**Case Officer:** Sarah Greenall

**Proposal:** Discharge of Conditions 3 (windows and doors joinery), 4 (slate sample) & 6 (landscaping scheme) of 21/03592/F

DATE: 10 August 2022

Condition 3 Fixed Windows - L2i

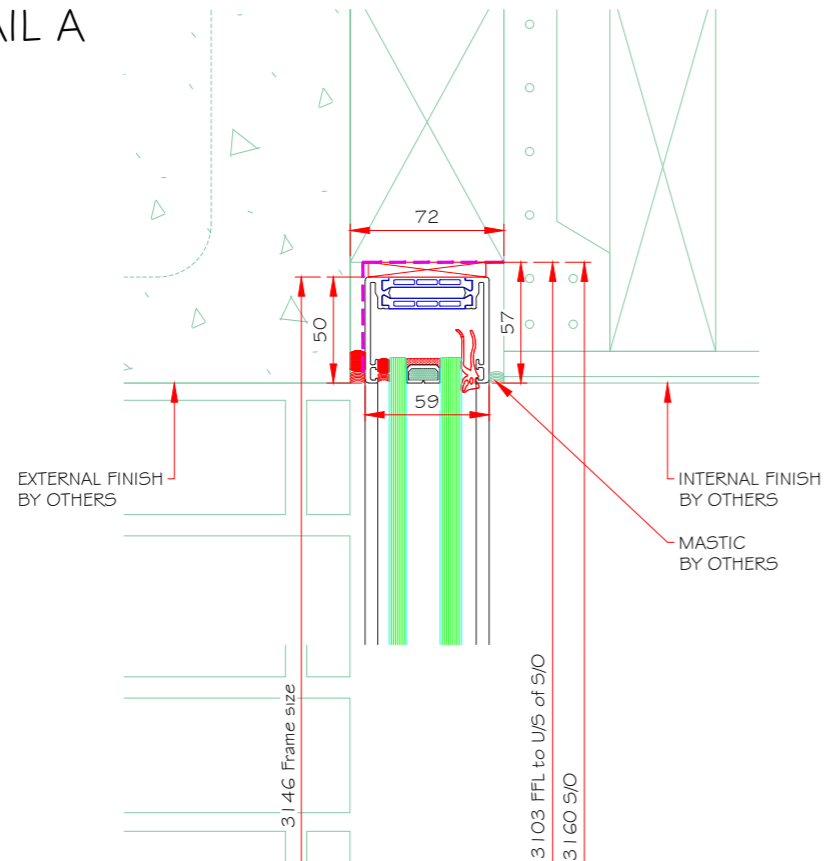
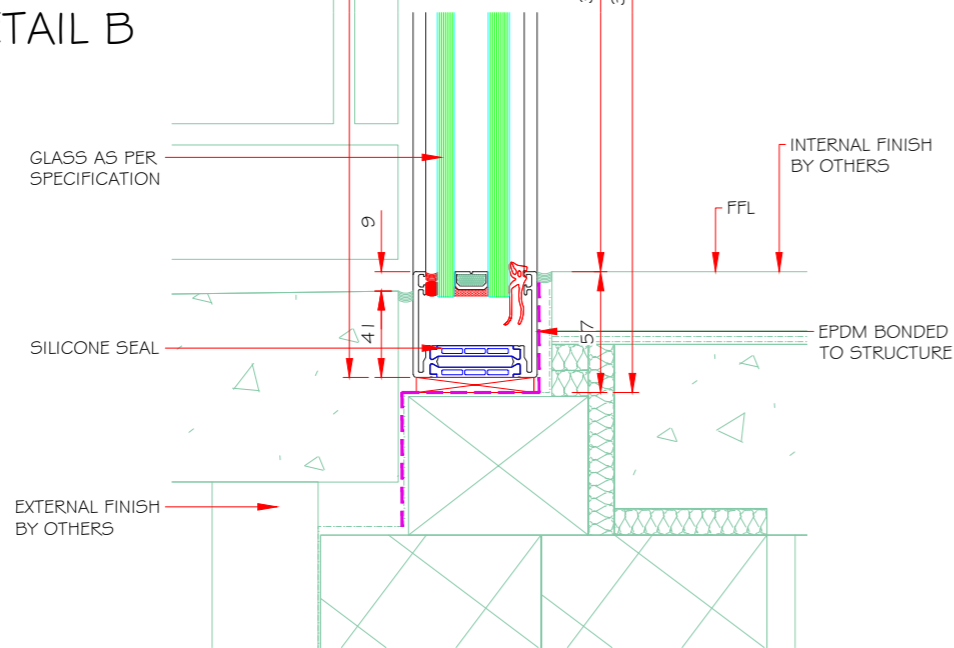
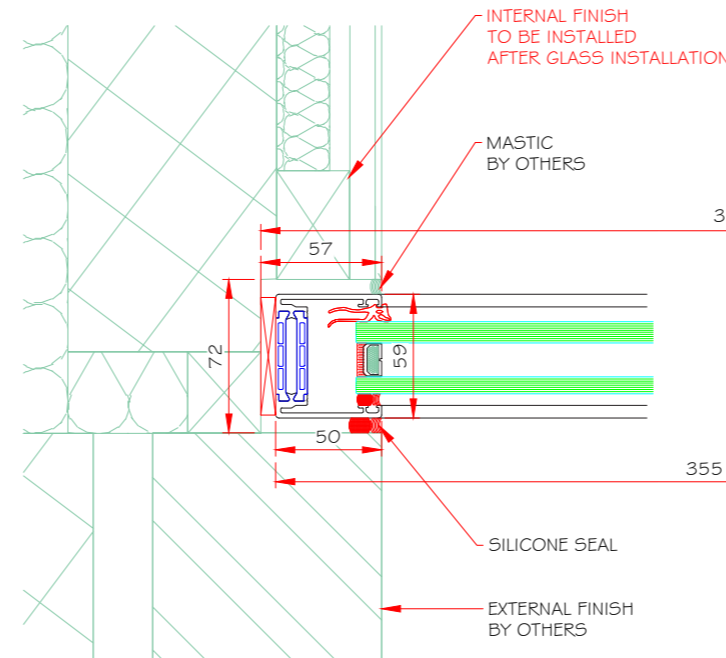
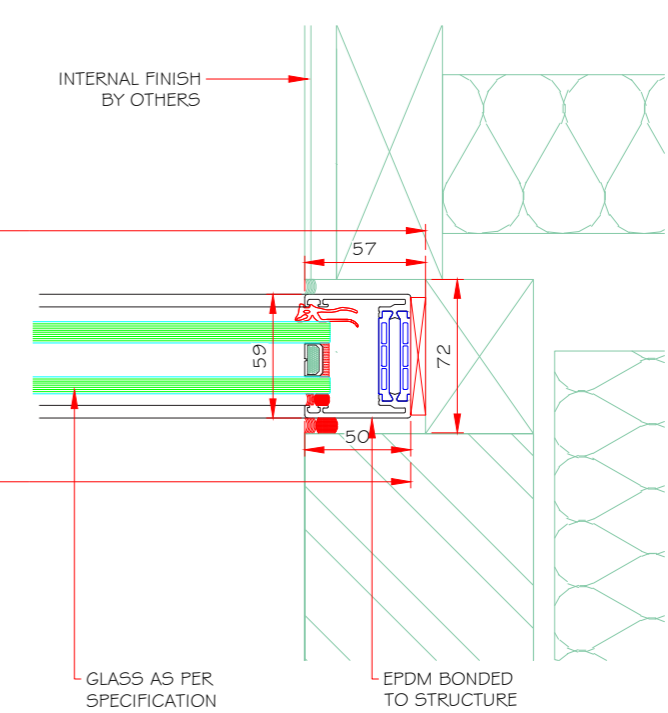
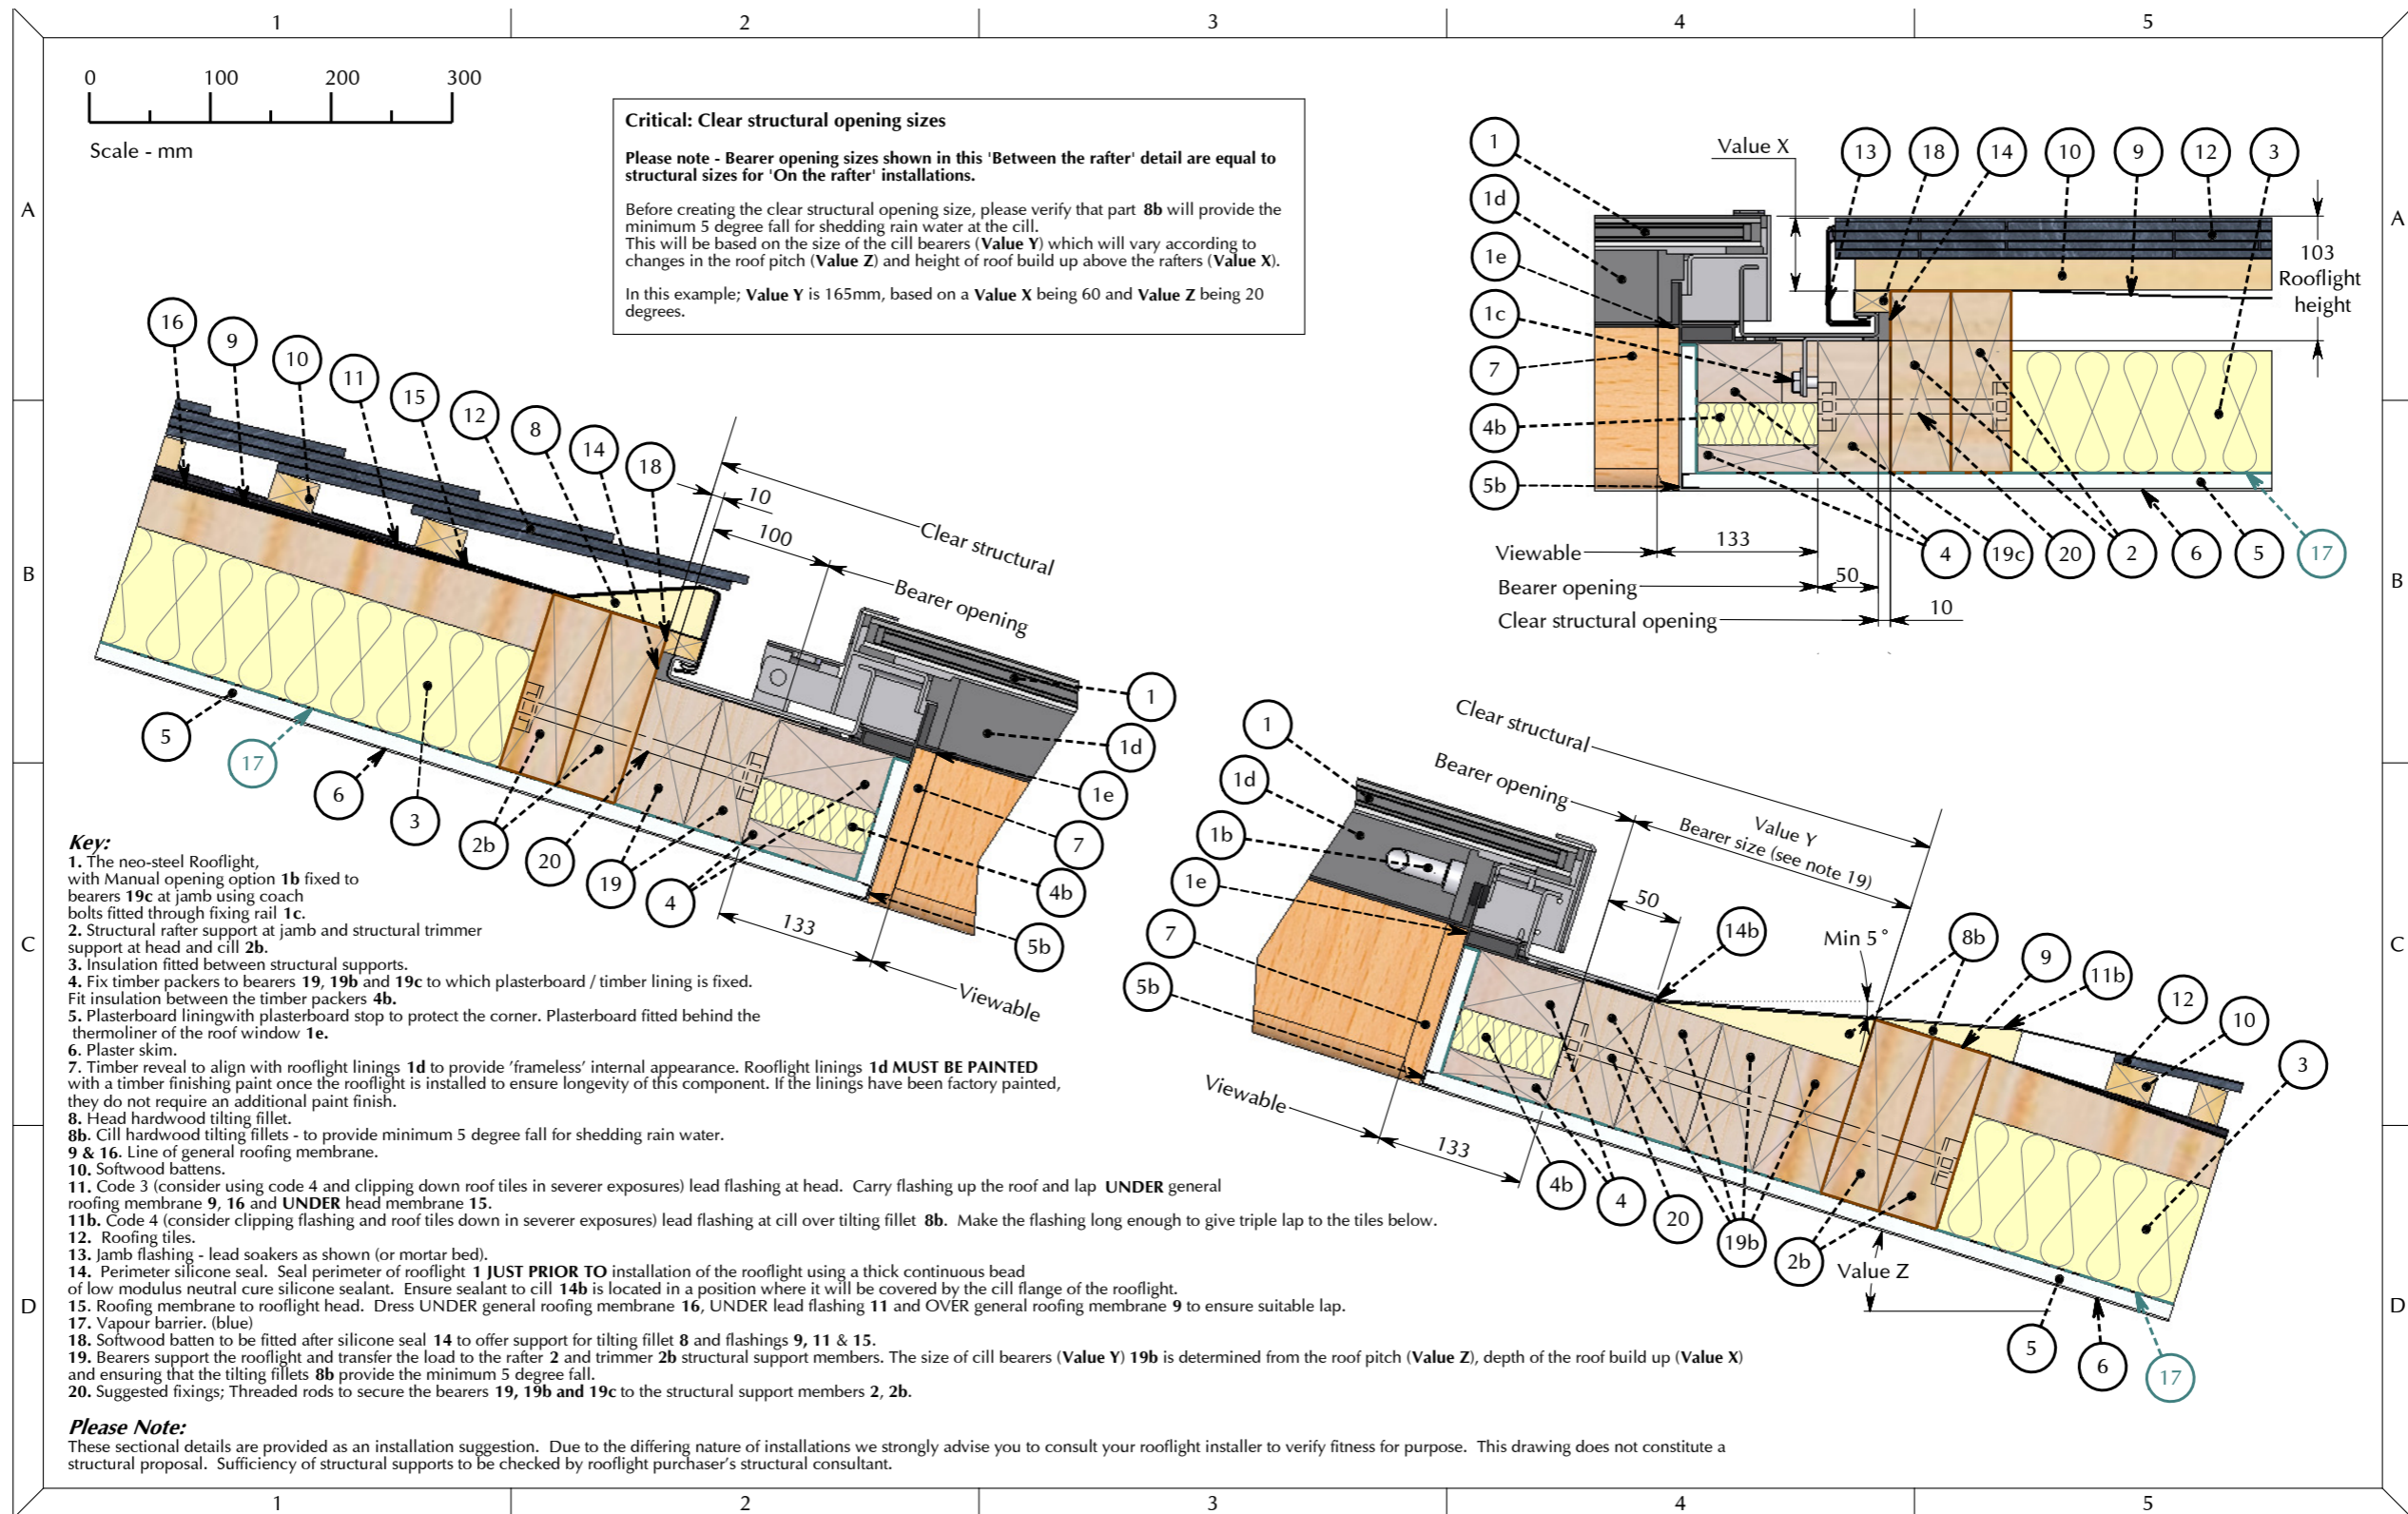
6.1. The applicant has submitted a Planning Conditions Schedule, which includes details of the joinery for the proposed building. The details show the glazing would be slimline and finished in powder coated anthracite grey aluminium. This is considered to be appropriate for the context of the building and would not result in harm to the setting of the listed building. The Conservation Officer has confirmed this would be acceptable and it is therefore considered the submitted details are acceptable.

Window and door joinery in accordance with page 3, 4 and 5 of the Planning Conditions document produced by Studio Hallett Ike dated March 2022

Condition 4 Slate Sample

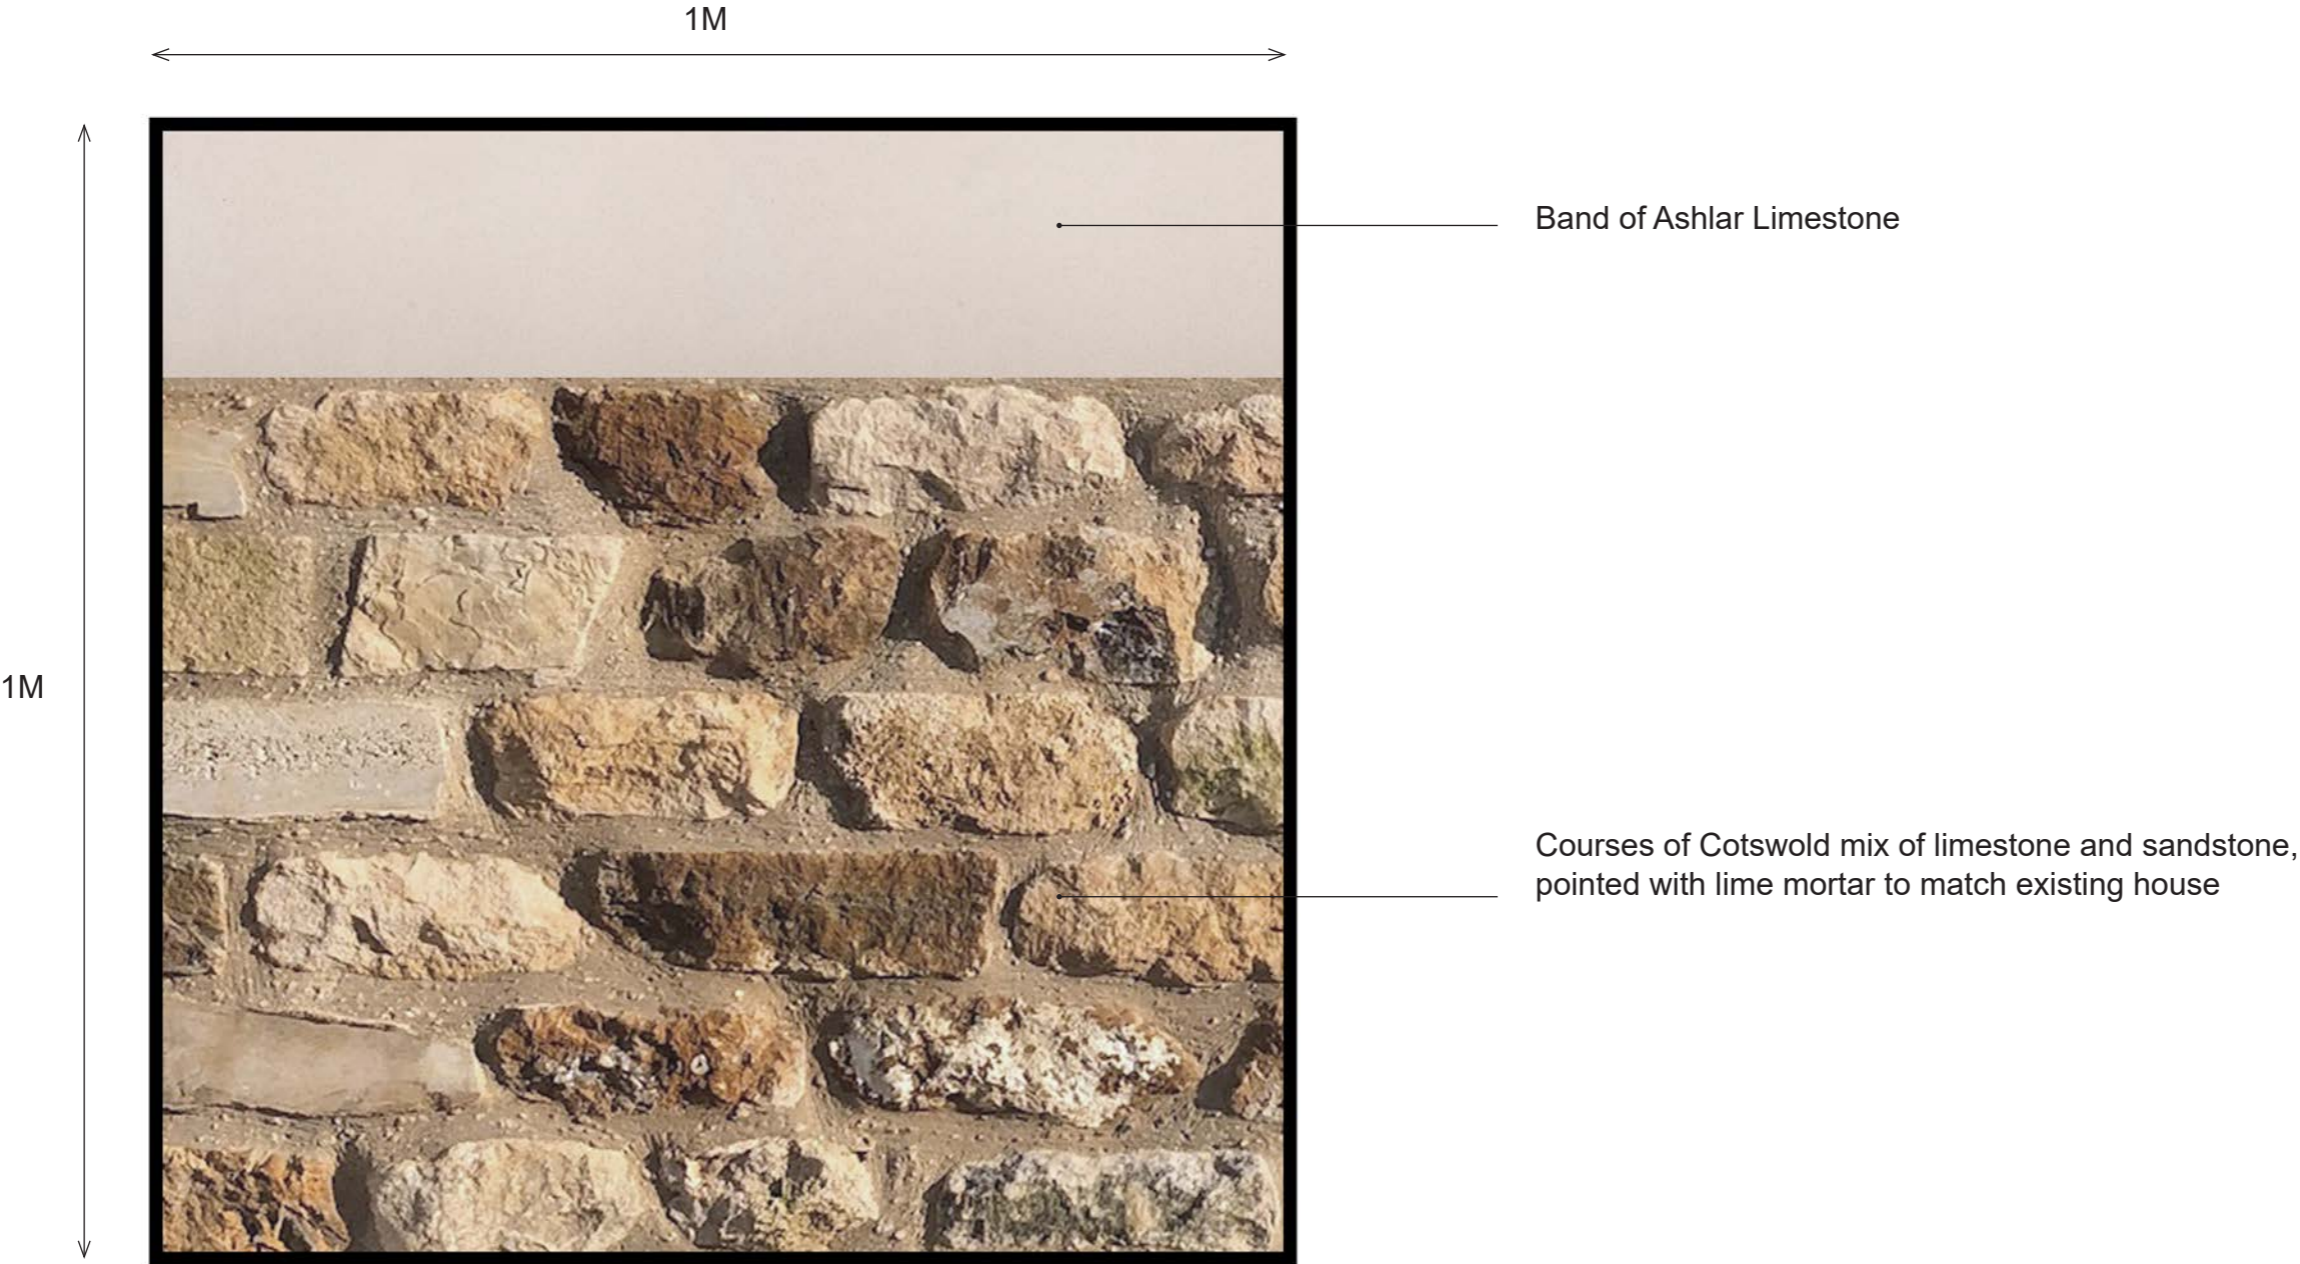
6.2. The Planning Condition Schedule includes a schedule of materials for the roof and external stonework. Spanish slate sourced from SIG roofing, a company used through the Cotswolds, has been proposed for the roof which is considered an acceptable approach. The Conservation Officer has advised that this would be acceptable for the building, and it is therefore considered the materials would be in character with the area and would not impact the setting of the listed building. The details of condition 4 are therefore considered acceptable.

Roof slate in accordance with page 5 of the Planning Conditions document produced by Studio Hallett Ike dated March 2022, and the email received on 9<sup>th</sup> August 2022.
